Application for a Non-Material Amendment Following a Grant of Planning Permission

Proposed 1.5, high 'ball top' fencing to the existing masonry wall boundary, including magnetic locks and audio intercom system.

3/2026/0426

L06 - 13998 - Proposed Elevations

South Facing Elevation
(Proposed)

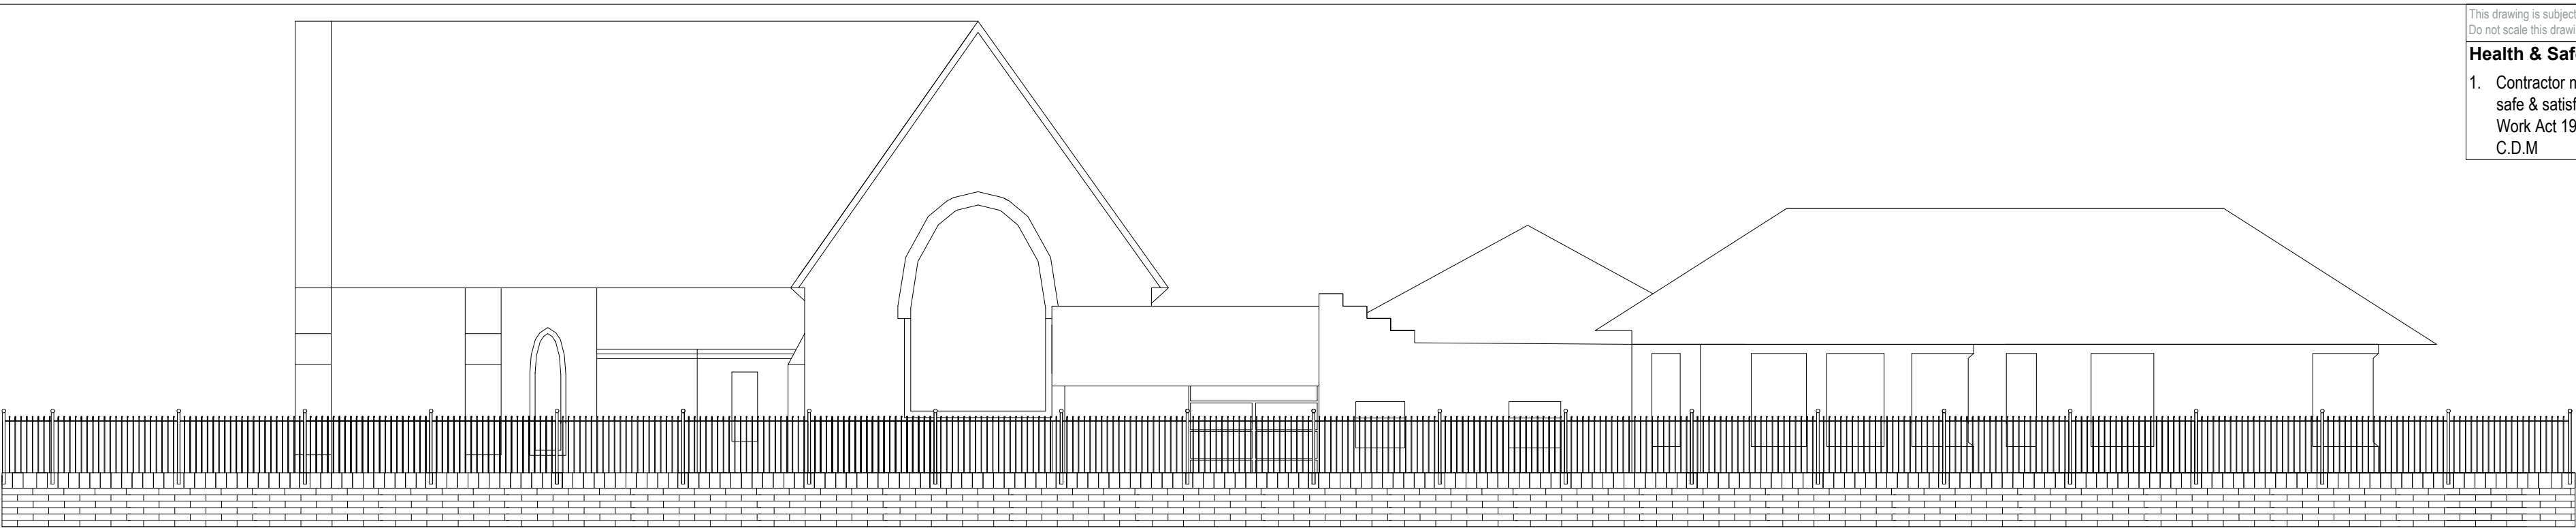
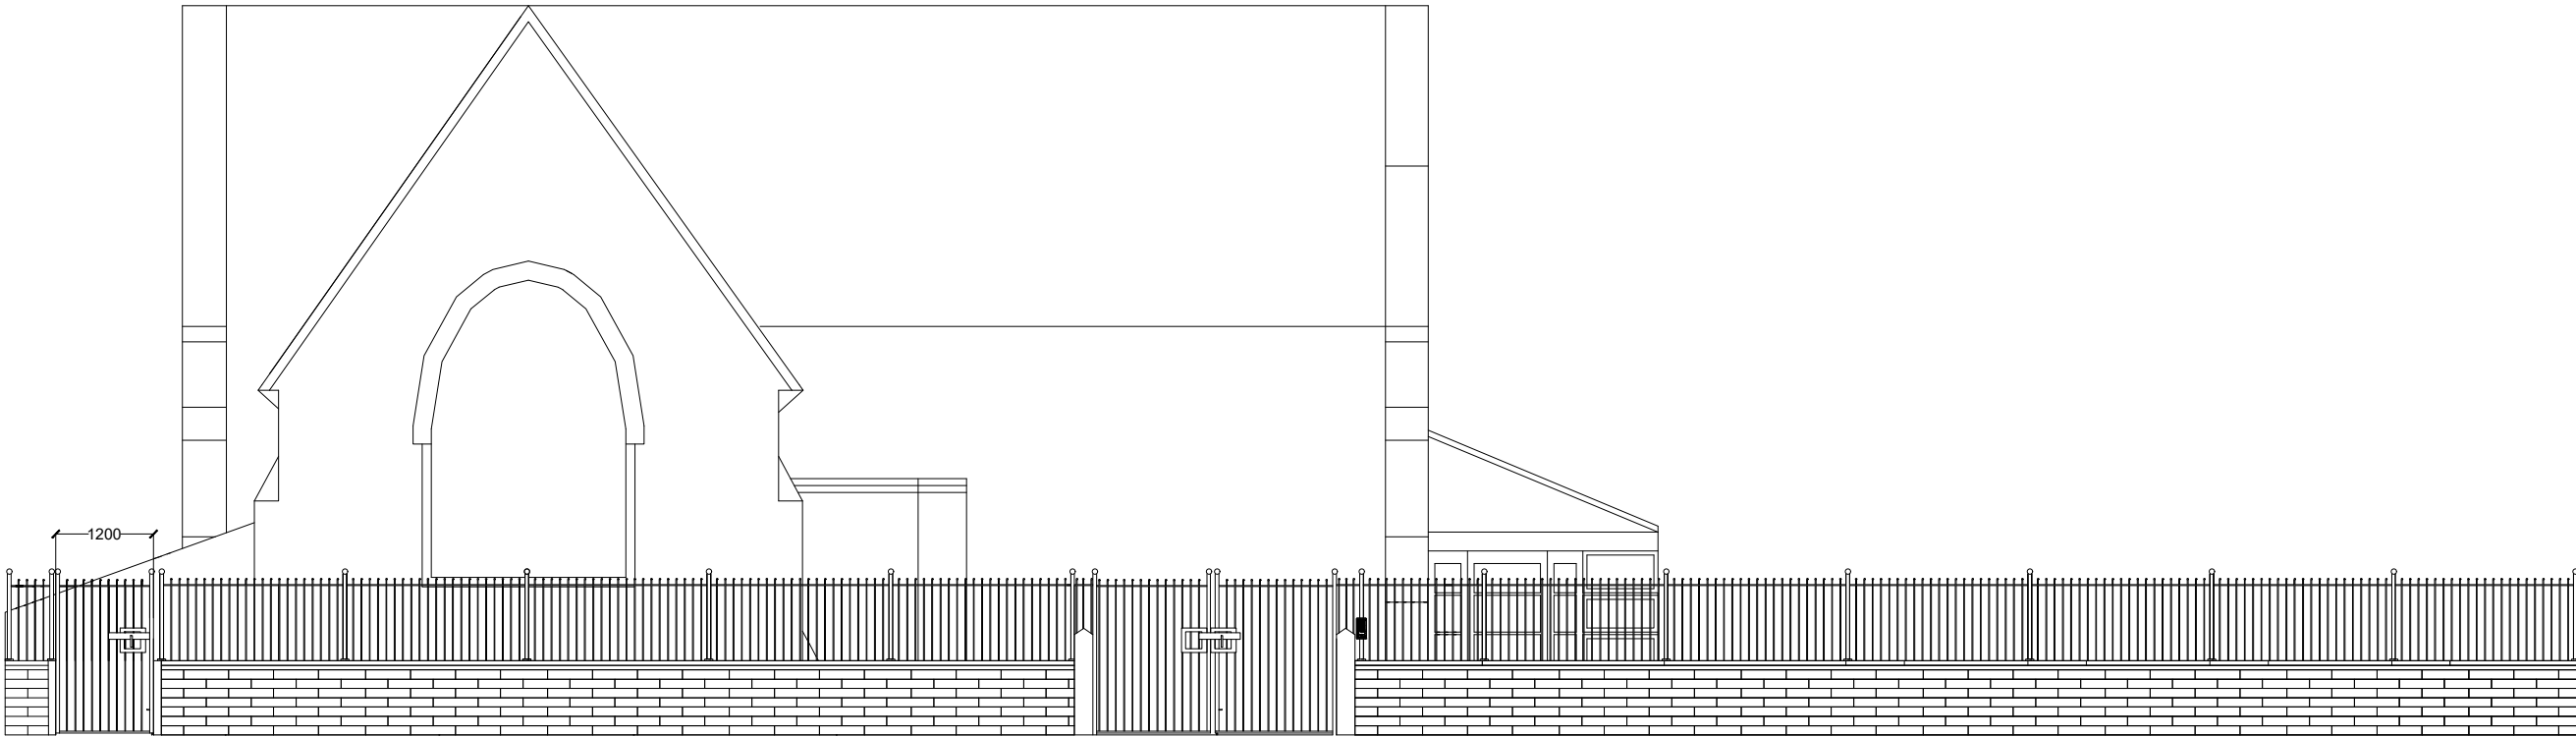
1 - 1No. audio intercom removed from single leaf pedestrian gate.
2 - 1No. audio intercom moved from gate to fence post.
3 - Fence posts to the fence length on the western elevation to be mounted on base plates to be bolted to the wall.
4 - Fence posts to the fence length on the south elevation to be mounted on brackets to be bolted to the wall.

1 - intercom system deemed redundant, and was omitted from the scheme
2 - the position of the audio intercom would have interfered with the operations of the gate
3 - Fence posts installed in this way would more closely fit other installations of fencing in the area, and would allow the fencing to be more flush with the stone masonry wall.
4 - The wall on this elevation is not perfectly straight, and so with the previous method of fixing the fence panels may have protruded from the wall, as such this method allows the panels to be more flush with the length of the wall.
